PINS Reference EN010169

Meridian Solar Farm.

Soils, Agriculture and Land Use Impact

Report of Reading Agricultural Consultants

Figure 3: Proposed Auger Locations within Inaccessible Areas for Area 1 (Highlighted in Red (inaccessible areas) and Grey (not surveyed))

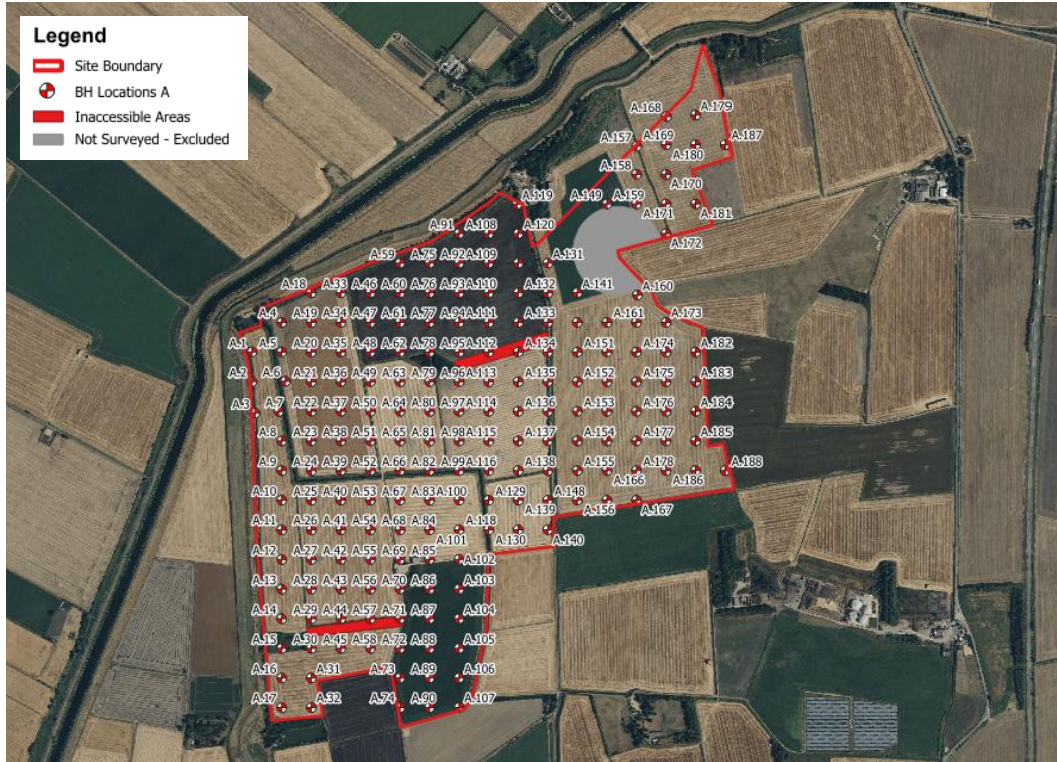
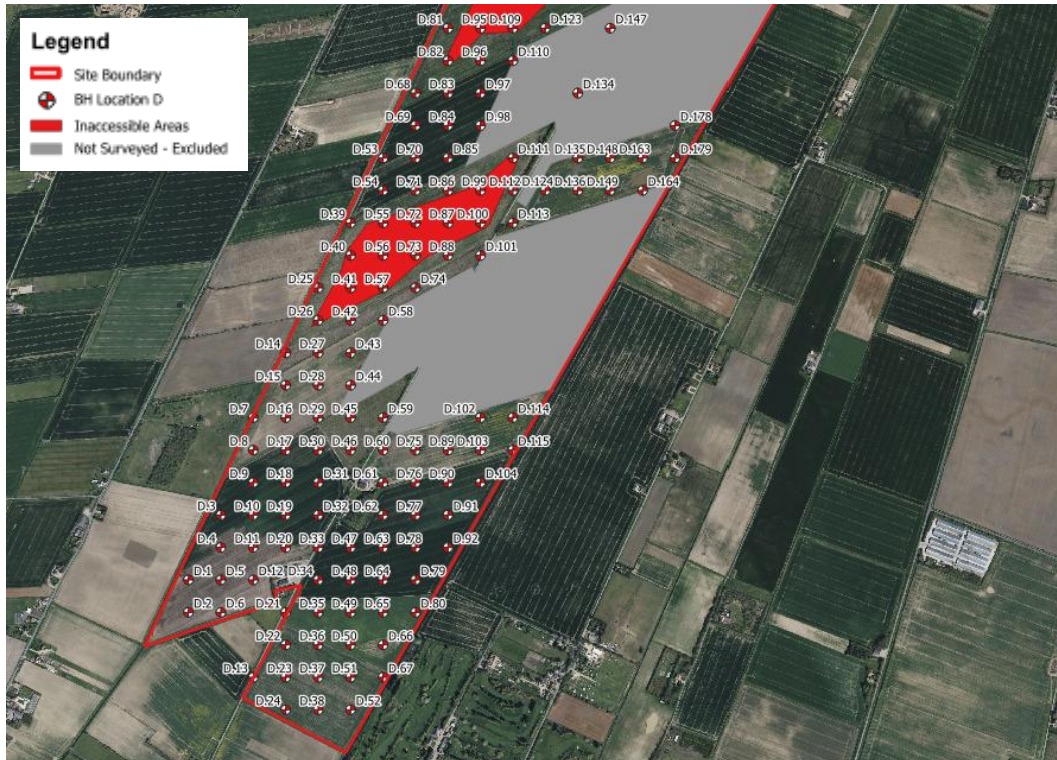
EN010169-000601 6.3 ES Appendix 5-2: Agricultural Land Classification Report - Parcels A and D (Rev 1) (Tracked)	
Para	Comment
3.3.4	Comment: Whilst additional samples have been collected from across areas unsurveyed at the time of the original surveys, no additional, adequate, soil pits have been dug in order to verify the findings of the soil survey and the observations made from the archaeological trenches.

Figure 6: Soils Mapping for the Site and Surrounding Area

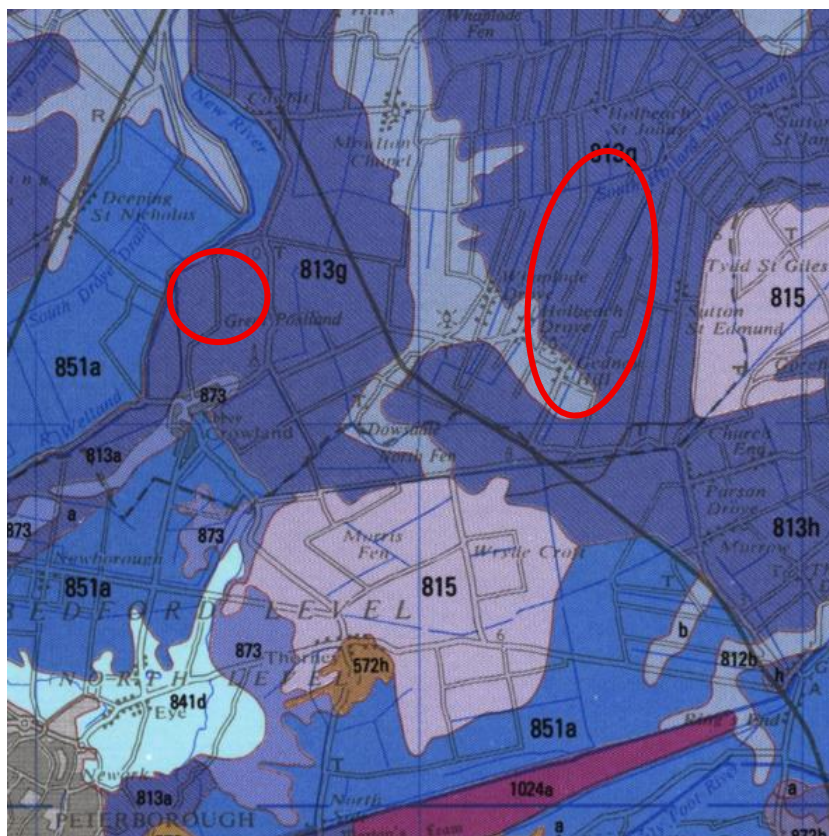
4.6 (previous reports)	As with the report describing Areas B & C, this review does not acknowledge the existence of detailed guidance on the soils of the area set out in the Boston and Spalding Soil Memoir and accompanying mapping.

Figure 4: Soils Mapping for the Site and Surrounding Area (site location indicated in red)

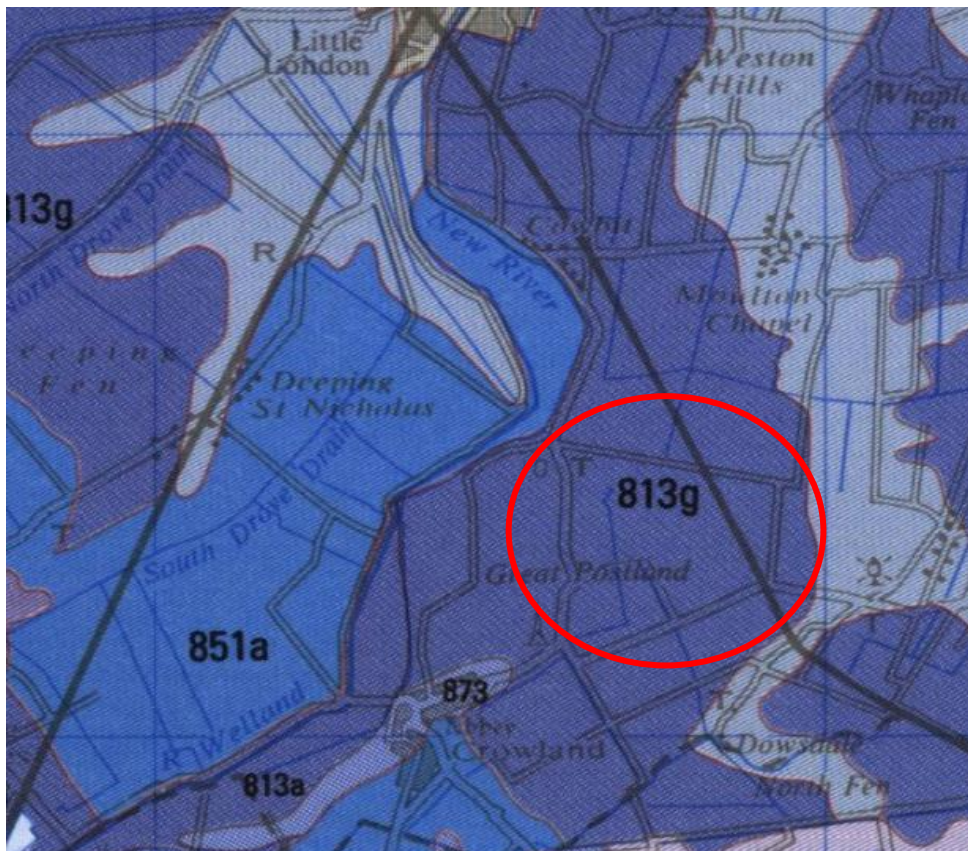
4.5 & 4.6 (previous reports)	The description of published sources of information about the soils of the area fails to identify the Boston and Spalding Soil Memoir and accompanying 1:50,000 scale mapping of soils series'. The review refers only to Soils and their use in Eastern England and the accompanying 1:250,000 scale mapping of soil associations. This scale of mapping can only be used to identify features hundreds of metres across and should only be used for national, or regional-scale environmental planning, rather than precise local or field-specific decisions.

Extract of MAFF Guidance Figure 6

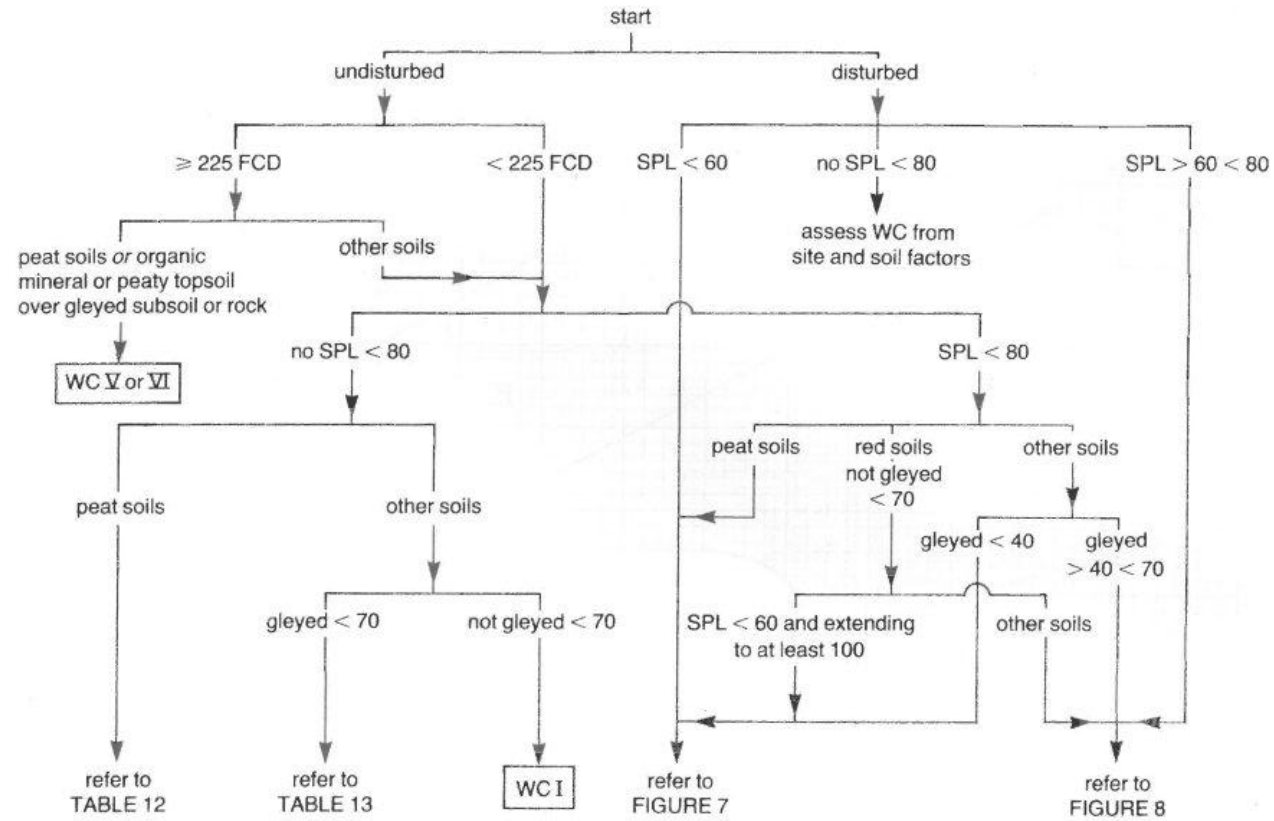
5.3.1	The Wetness Class assigned to Soil Type 2 conflicts with the findings of work carried out by MAFF and the Soil Survey of England and Wales (SSEW), which puts the Wallasea series in Lincolnshire in WC II. This work was based on an intensive deployment of piezometers by the MAFF Field Drainage Experimental Unit and dip wells by the SSEW throughout the area. Drained Wallasea series were found to be in WC II and occasionally in WC I. It is extremely unlikely that an auger survey carried out in a very dry summer, when the soils are described as too dry for pit digging,
